**Re: San Jacinto Ave NE**  
**12710 San Jacinto Ave NE**  
**Traffic Circulation Layout**  
Architect's Stamp 02-28-2022 (K22-D063)

Based upon the information provided in your submittal received 02-28-2022, the above referenced plan cannot be approved for Building Permit until the following comments are addressed:

Date: April 19, 2022  
Sheet: Site Plan

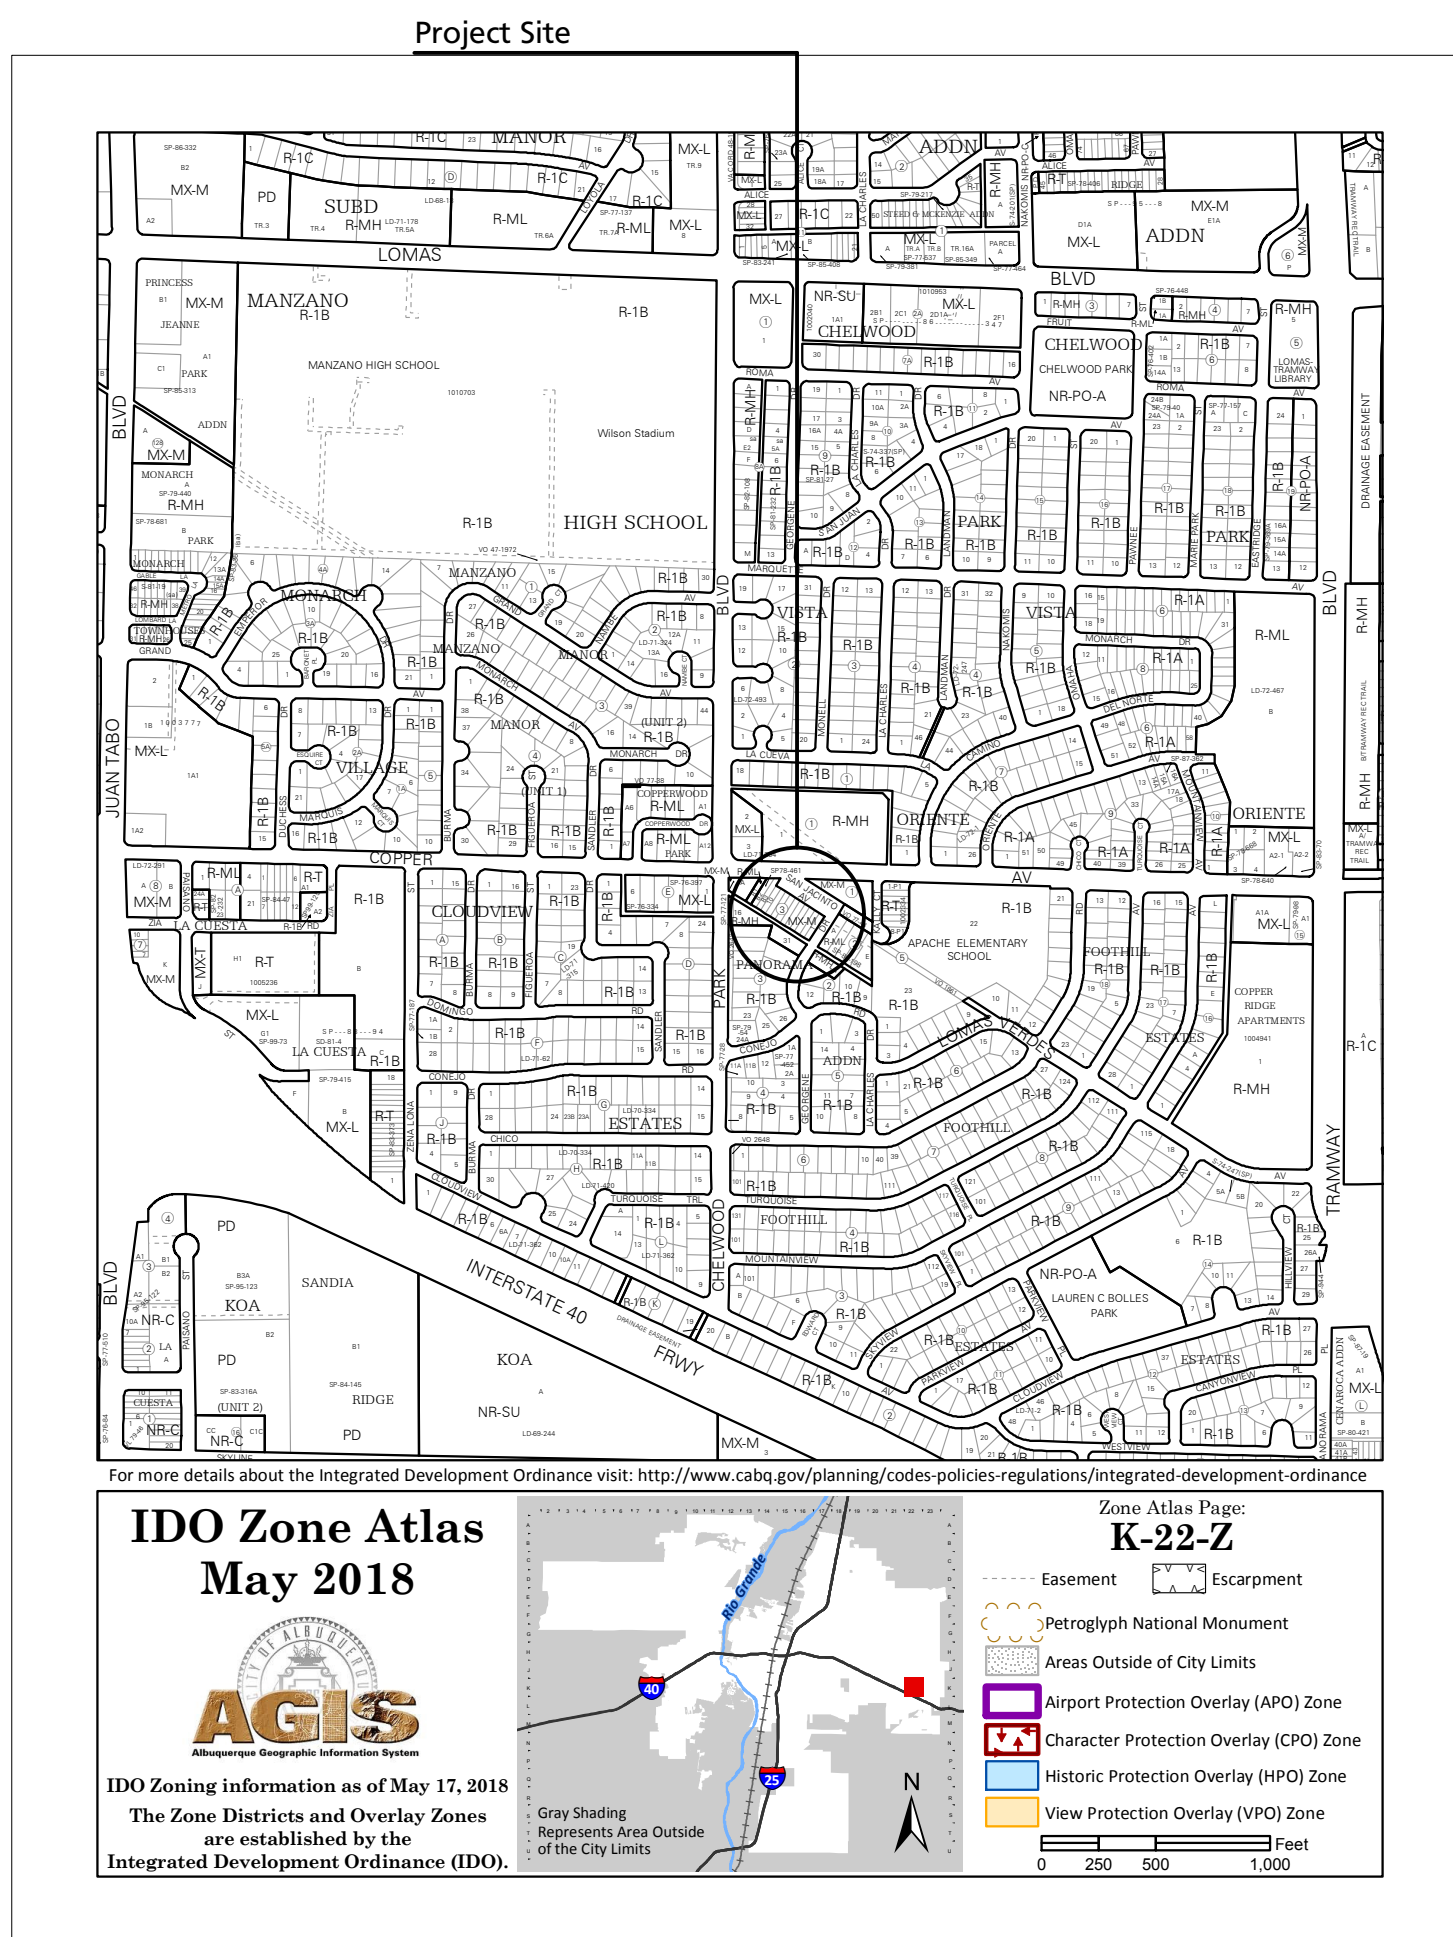
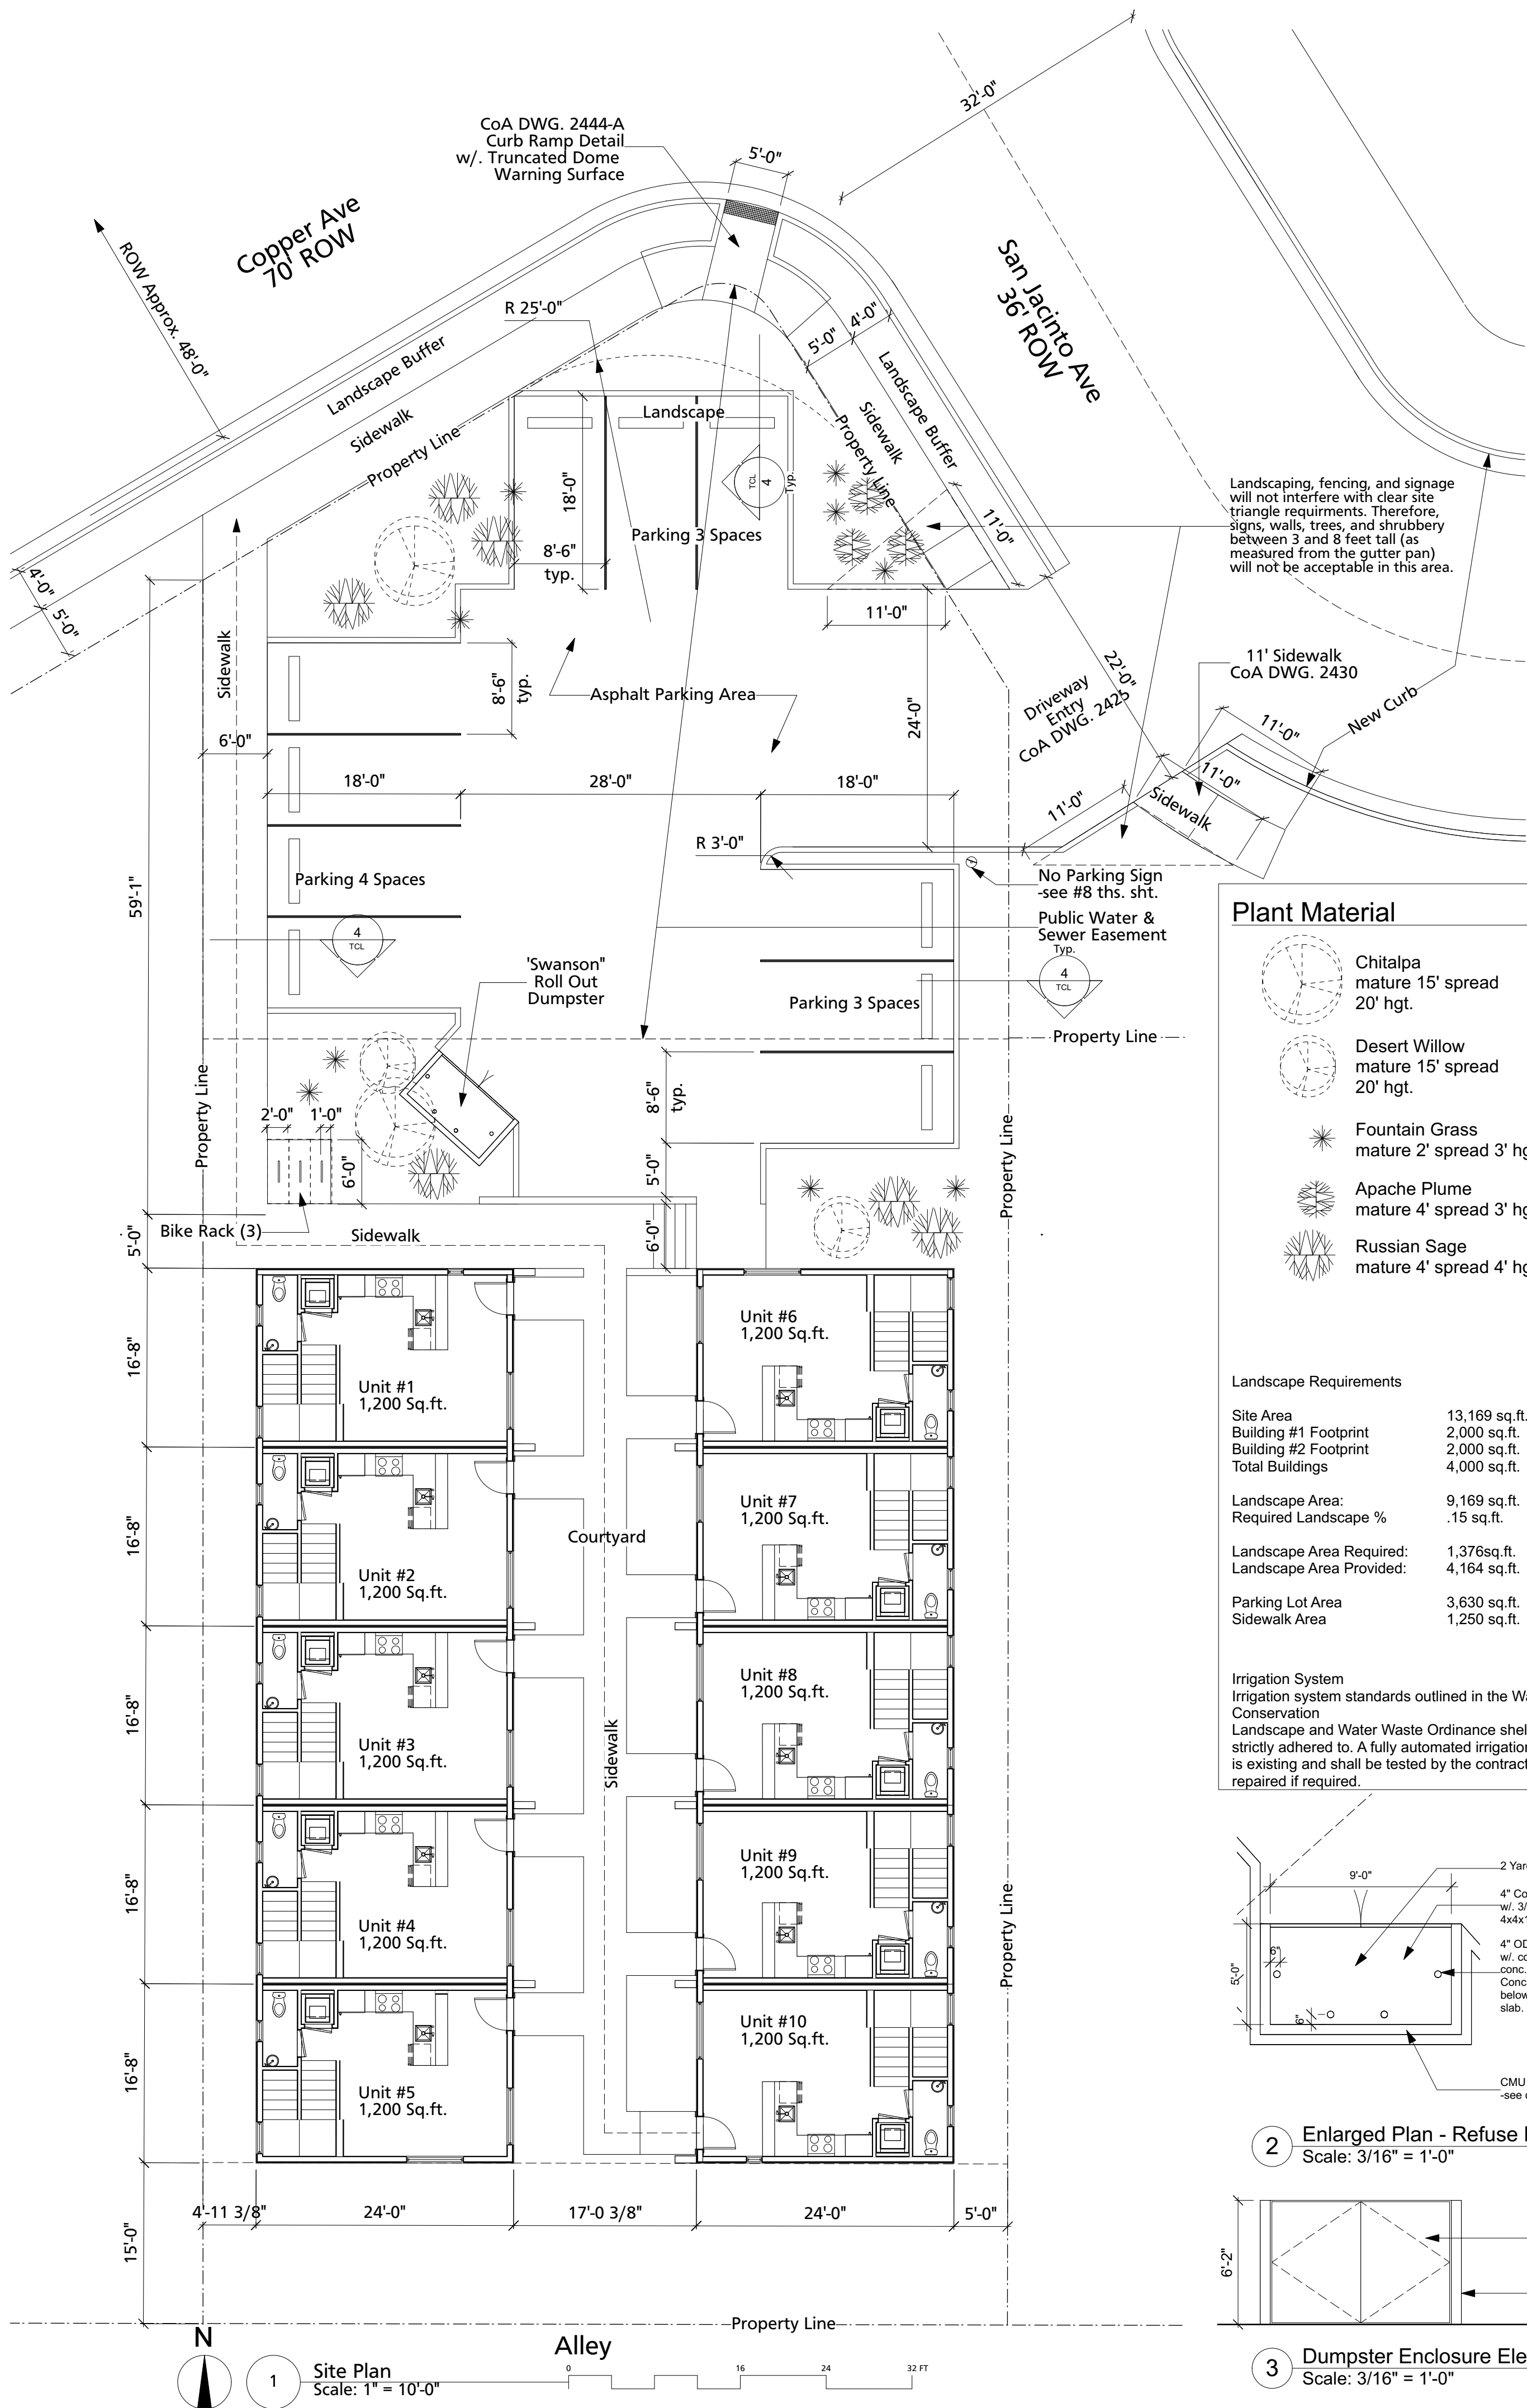
1. **The following infrastructure items need a reference note that it will be built under Work Order 749882 and not TCL Site plan approval:**
  - Corner proposed ramp (Copper/San Jacinto).
  - Proposed 5 feet sidewalk segment from ramp to proposed driveway.
  - 22 feet driveway(proposed).
  - Alley work proposed.
2. **San Jacinto frontage:** The 5 feet proposed sidewalk with a length of 11 feet beyond proposed driveway will need to be built on TCL submittal and please reference COA std dwg 2430.
3. The proposed parking stalls appears to be located on the proposed 28 feet drive aisle. Please fix/adjust this concern.
4. **Condition of Final C.O. approval:** Work Order 749882 constructed and approved by COA will be set on TCL approval set by me.
5. A copy of receipt for resubmittal fee's paid will need to be provided.
6. Please provide a letter of response for all comments given.
